Ribble Valley Borough Council  
Housing & Development Control

Your ref: 3/2023/0272  
Our ref: D3.2023.0272  
Date: 4<sup>th</sup> May 2023

Application no: **3/2023/0272**

Proposal: **Demolition of detached collapsed storage building and erection of one two-storey dwelling with private garden and parking areas. Erection of a two storey outbuilding, providing garage and hobby room serving Twinbrook Barn.**

5765 - 16 Rev  
C

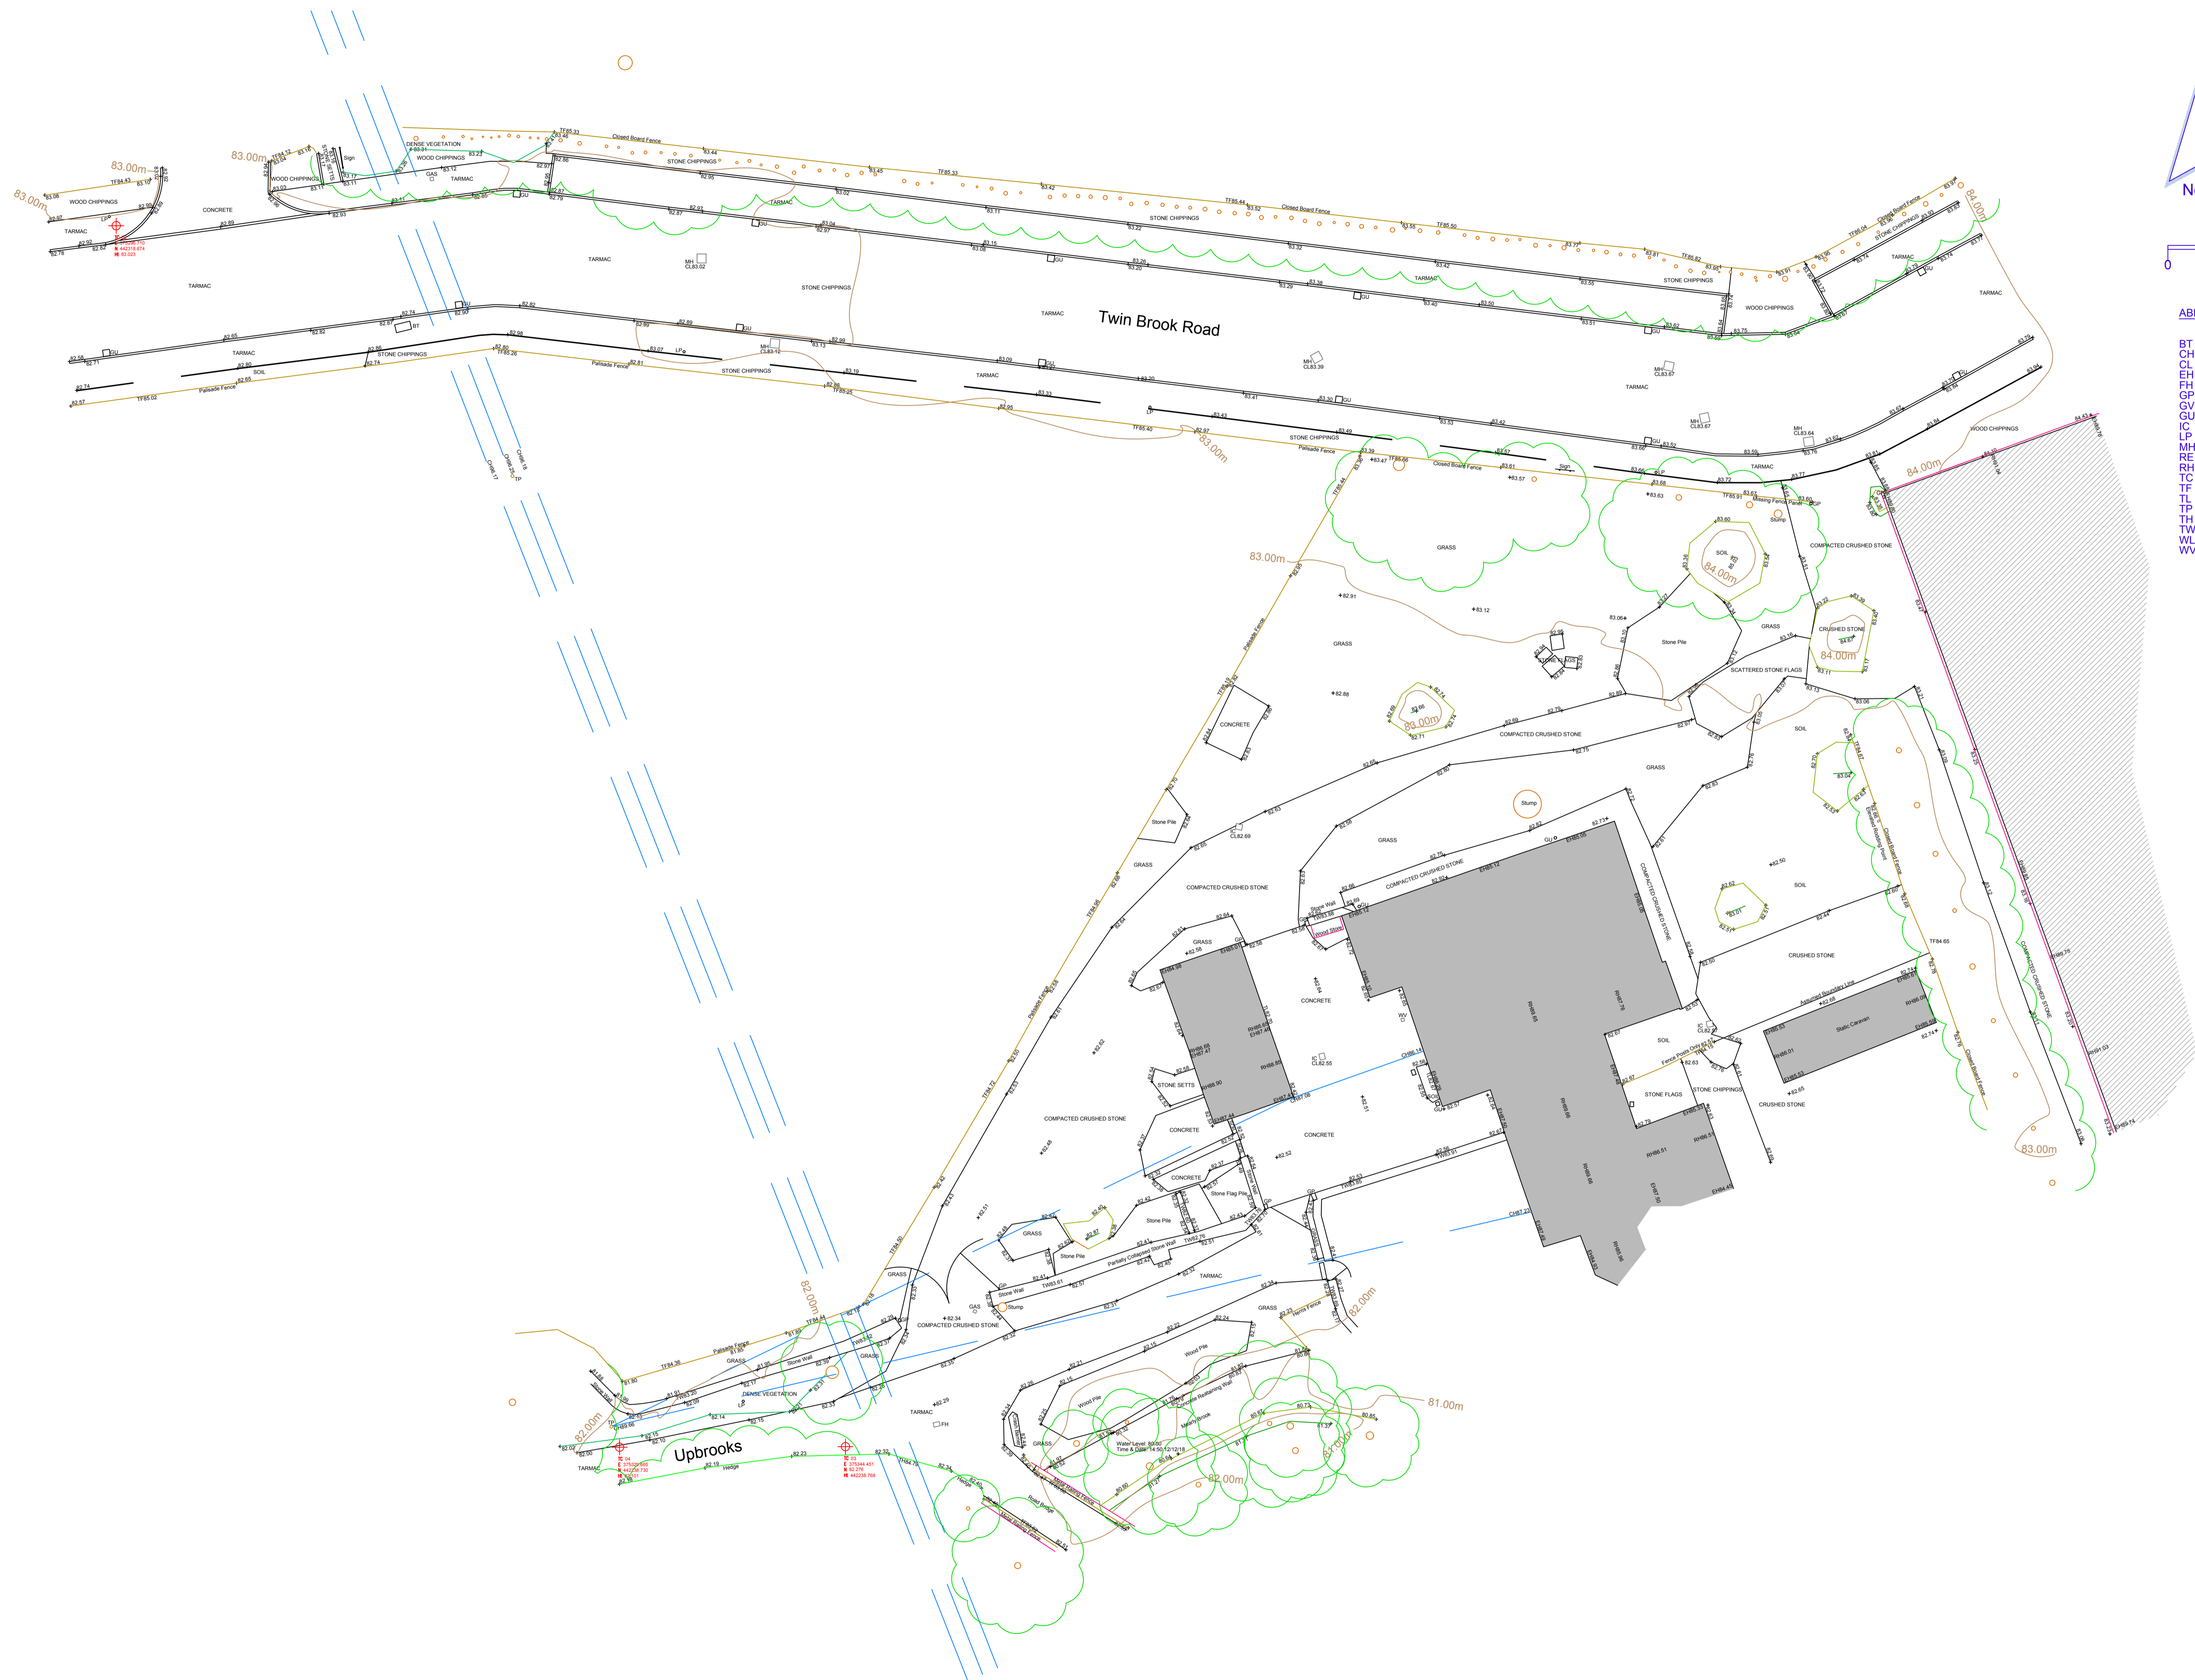
The LHA have reviewed SPA drawing number 5765-16 Rev C titled "Proposed Site Plan" and have no comments regarding the access with it complying with the LHAs guidance.

The LHA would prefer the gate to be setback 5m into the site but given that the section of the road serving the site and Twinbrooks Barn is not publicly maintained, the LHA are unable to request this.

The LHA have reviewed SPA drawing number 5765-16 Rev C titled "Proposed Site Plan" and are aware that 2 car parking spaces can be provided at the site which complies with the LHAs parking standards as defined in the Joint Lancashire Structure Plan.

The LHA will condition that a minimum of one car parking space provides an Electric Vehicle charging point and some form of cycle storage is provided.

3. The development hereby permitted shall not be occupied until such time as the parking and turning facilities have been implemented in accordance with SPA drawing number 5765-16 Rev C. Thereafter the onsite parking provision shall be so maintained in perpetuity.
